30th November 2021

Our Ref: A21C51

**RE: INDUSTRIAL DEVELOPMENT EXPANSION
2-14 DISTRIBUTION DRIVE, ORCHARD HILLS, NSW
SSD 18204994 - Responses to RFIs**

Figure 2.0 Flood Map – CostinRoe Flood Report

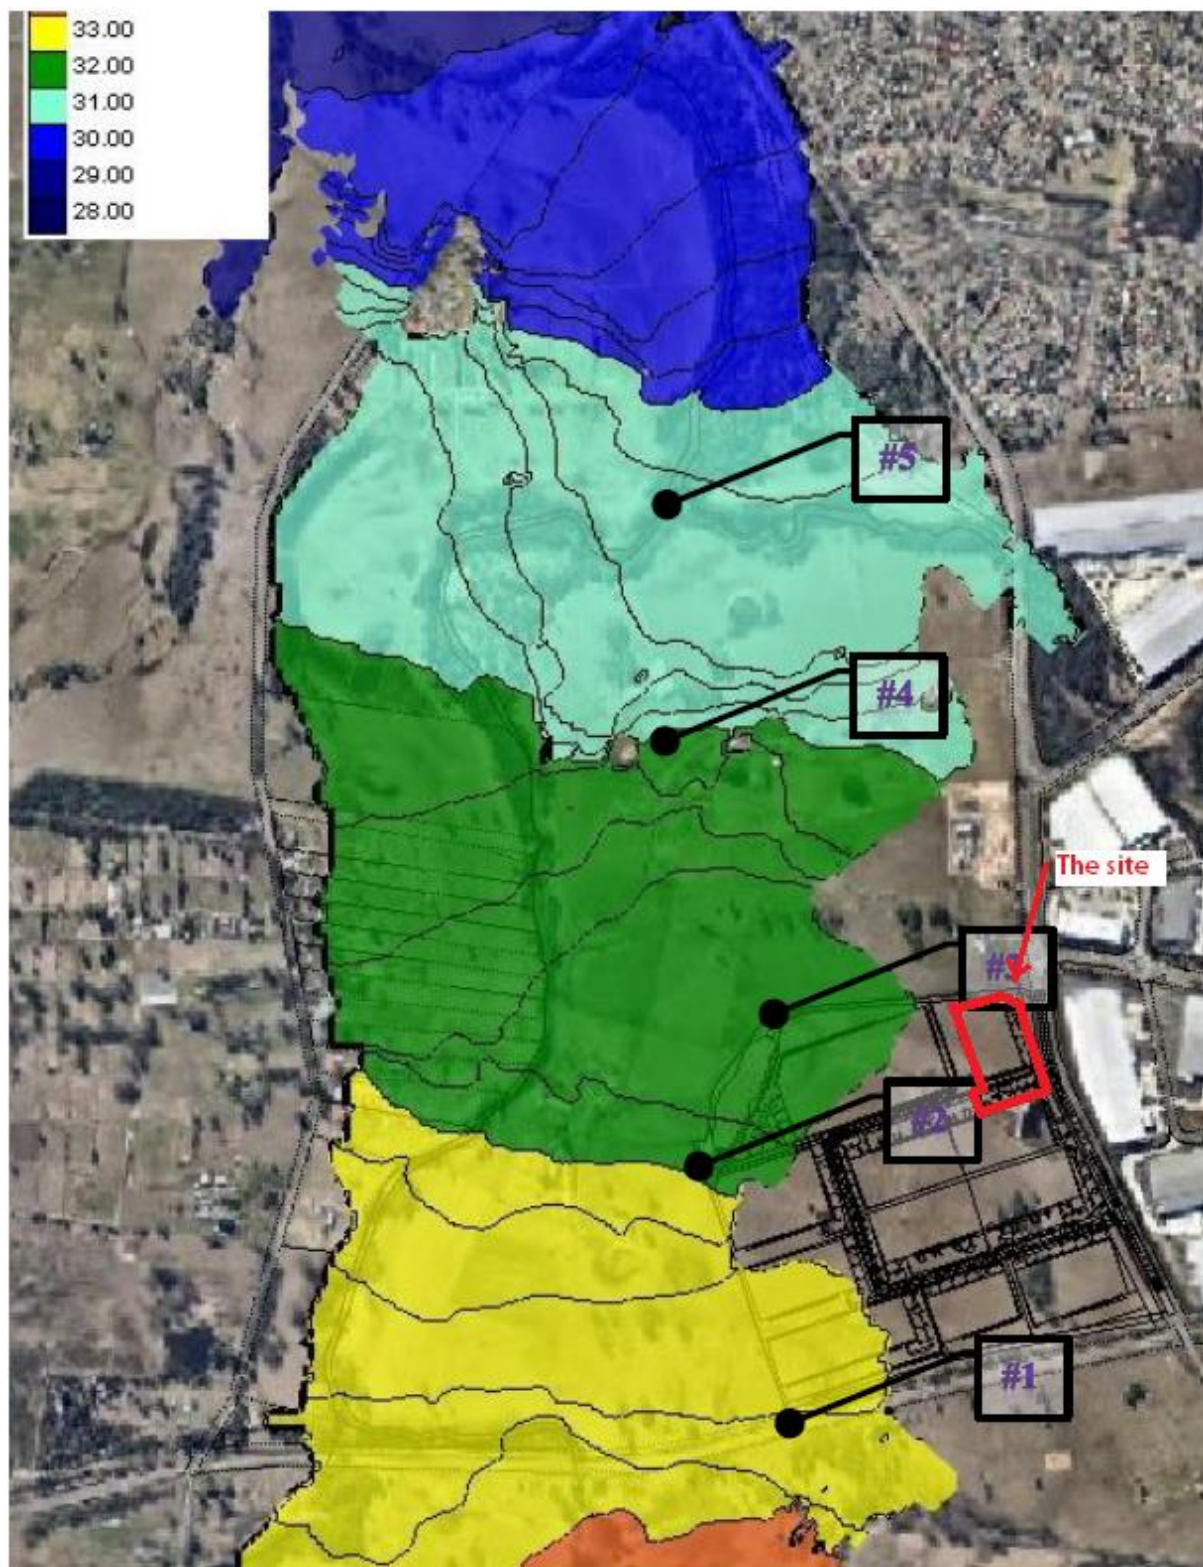
It is acknowledged that the site is not affected by mainstream flooding from South Creek in a 1% AEP flood event. The development site adjoins a stormwater channel, contained with the drainage easement (D), that was constructed as part of the parent subdivision works. Details of the stormwater flows within the channel were not provided with the application. The development must ensure that floor level of any warehouse structure is located at least 0.5m above the top water level of the 1% AEP flow within the stormwater channel contained within the drainage easement (D).

This stormwater channel was designed by Costin Roe Consulting and formed part of the subdivision works. The proposed building FFLs are at or higher than the proposed pad levels that formed the subdivision design. The documentation by Costin Row clarifies that the overland flow swale has the capacity to convey the 1:100yr ARI flows, citing a peak 100yr flow of 2.82m³/s (there is a 9.5ha upstream catchment). Since we are not proposing to make any adjustments to this swale (and our building FFL is significantly higher than the original pad FFL that formed the subdivision design) it is expected that the FFL has more than sufficient freeboard. At the most upstream (and conservative) section adjacent to the proposed building we have a building FFL of 36.75, and a swale invert of 33.68. This gives a 3.07m clearance from building FFL to the invert of the swale. Taking a very conservative approach and assuming a total flow depth of 1.0m – the top of water level would be 34.68 – giving a total freeboard of 2.07m.

2932m² ROOF AREA DIRECTED TO PROPOSED 50kL RAINWATER TANK. TO BE USED FOR TOILET REUSE AND IRRIGATION PURPOSES

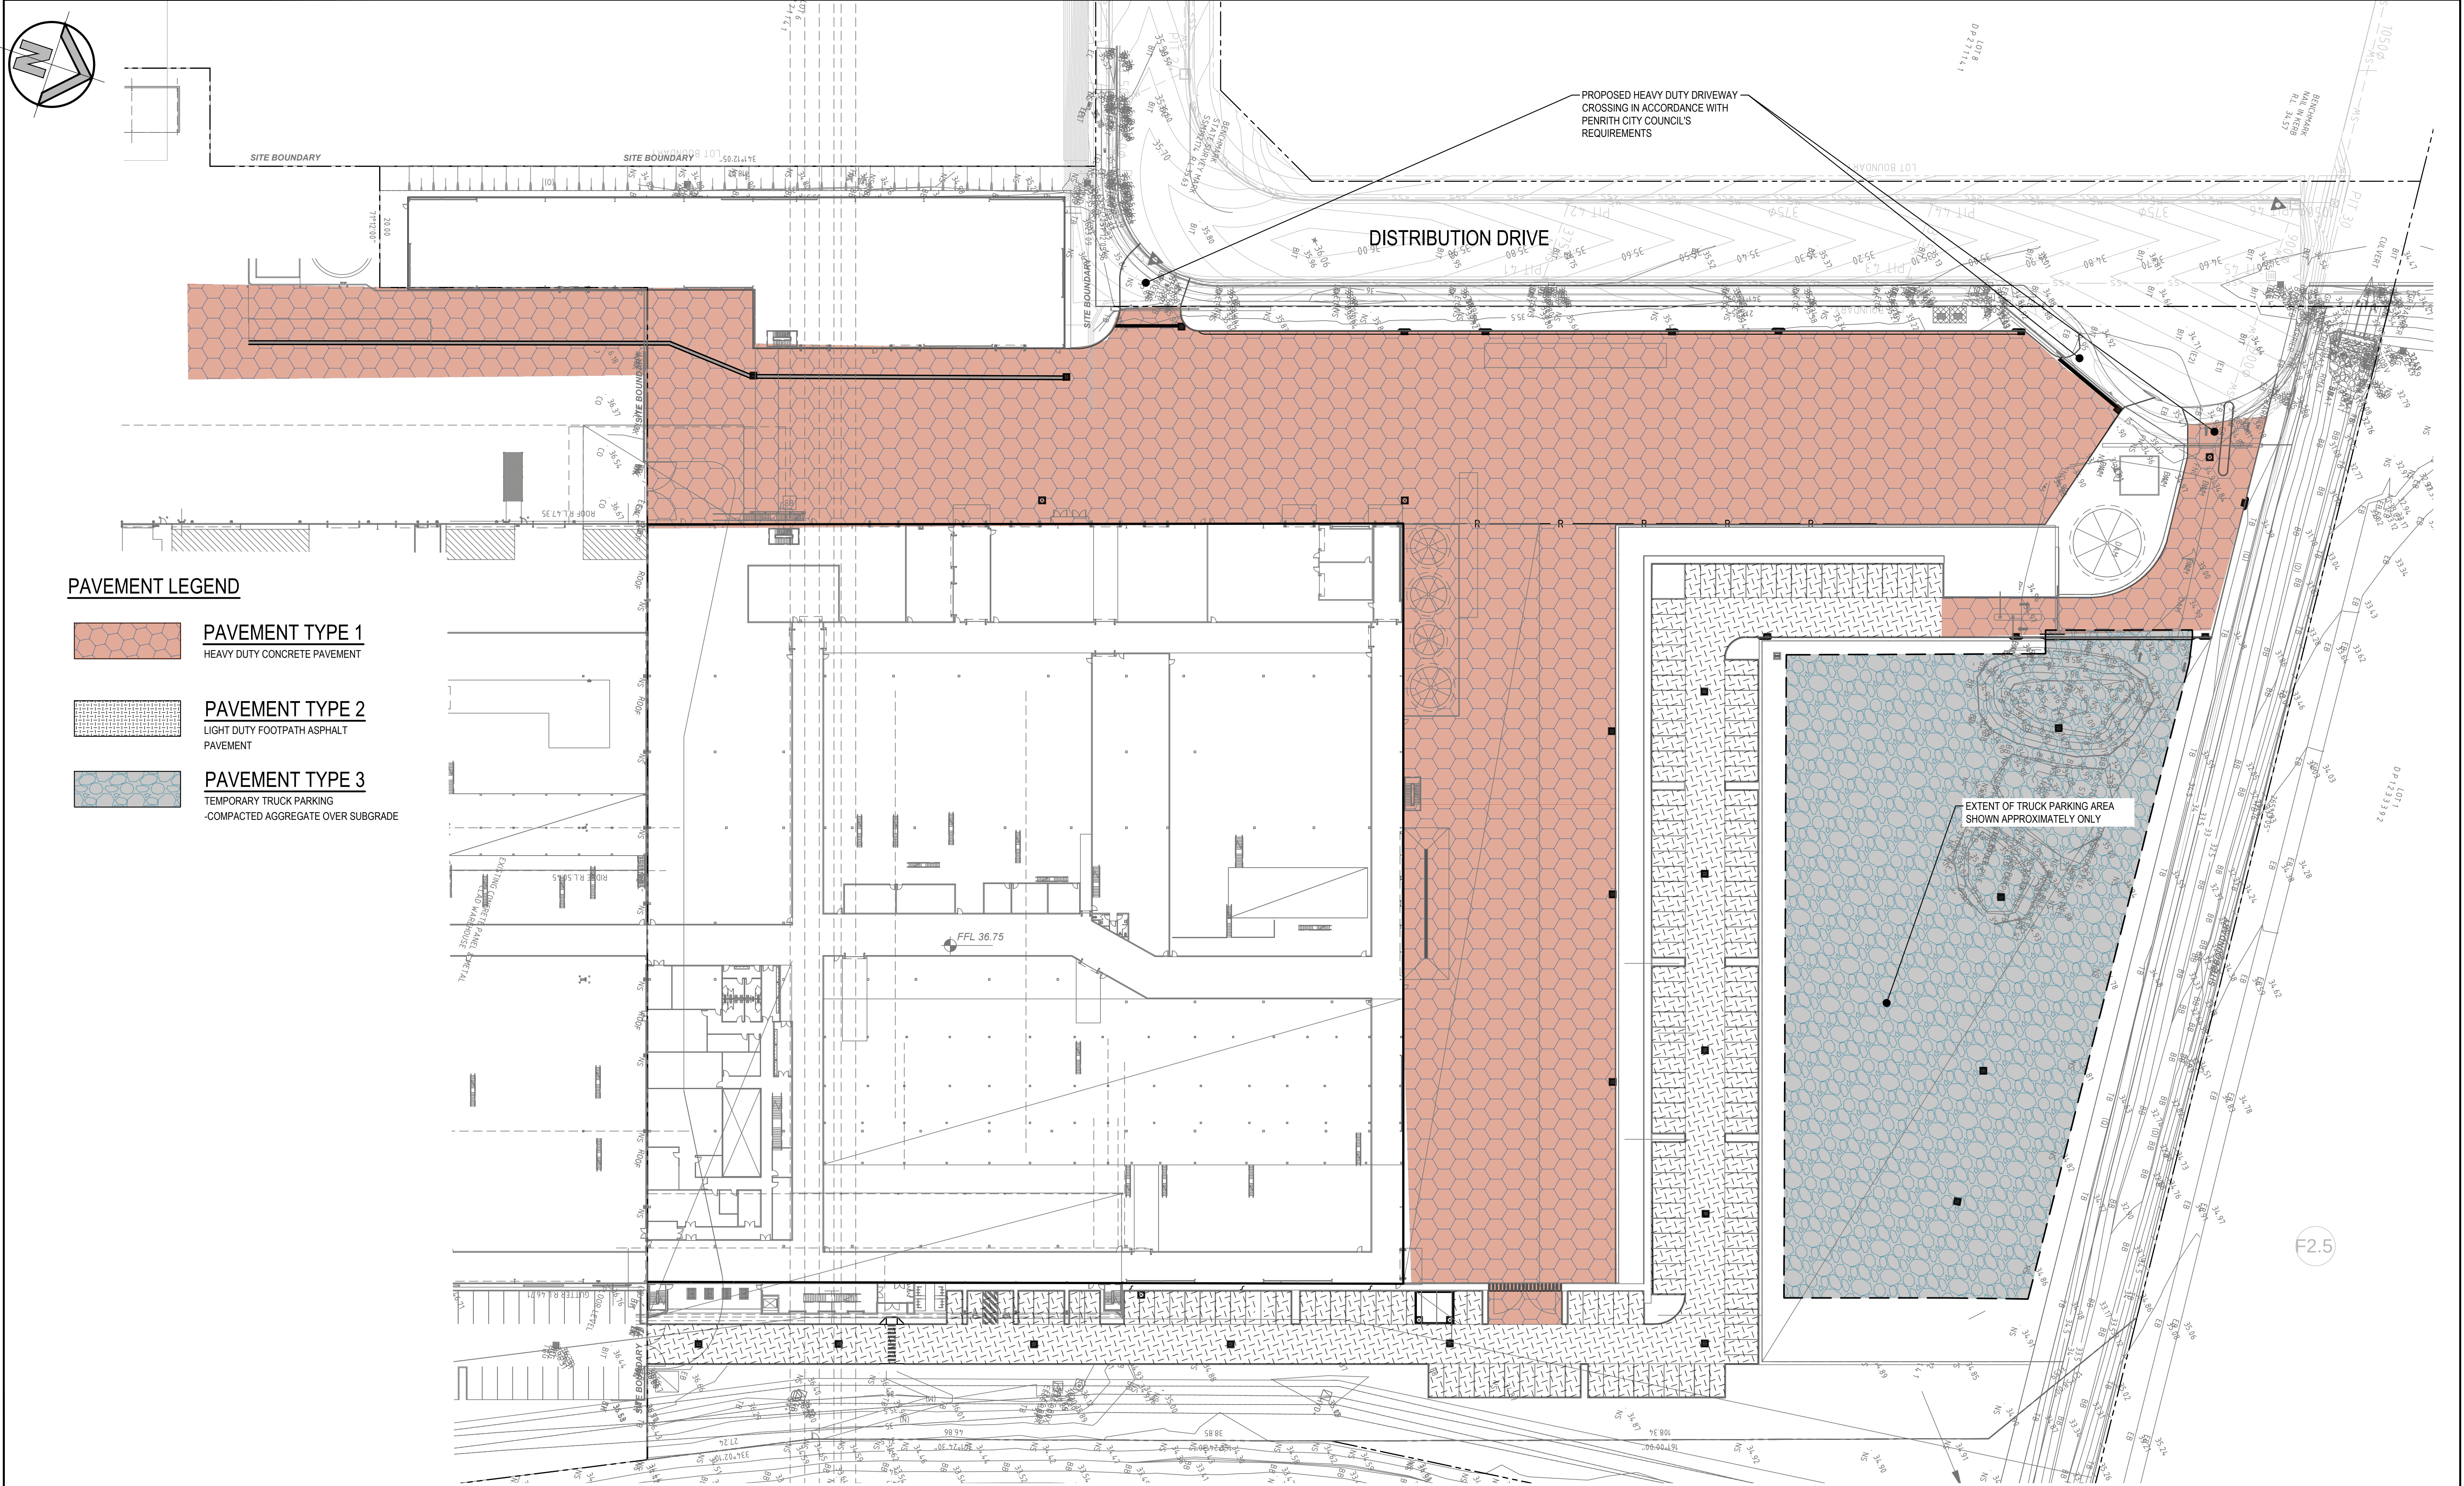
The proposed development will include a satisfactory stormwater management cycle which includes a Water Sensitive Urban Design (WSUD) strategy which achieves the relevant stormwater and pollution reduction targets across the site. Rainwater harvesting would also be applied across the site (where considered practical), which will incorporate re-use in irrigation methods and recycled potable water components, i.e. toilet flushing, roof wetting and irrigation. The applicant stormwater report states that both a 50kl and a 40kl rainwater tank are to be provided with a non-potable reuse demand of %80.37. The above comments above indicates compliance with Penrith Council's WSUD strategy. However, an electronic MUSIC model in sqz format should be made available to support the application as two different sizes of rain tank have been provided.

As summarised in the civil DA report, there is downstream infrastructure provided which caters for the water quality treatment of the entire subdivision, the subject site included. The downstream water quality infrastructure consists of a gross pollutant trap, and a bio-retention basin. It is not expected that any further treatment of the site stormwater is required.

A MUSIC model has already been provided (I have re-attached to this correspondence). The tank size has been modelled as a 40kL tank within the MUSIC software, however we have proposed a 50kL tank to be installed. The 20% increase is to account for the following factors which is not taken into account in the MUSIC model:

- Anaerobic zone
- Mains water top up levels
- Overflow levels
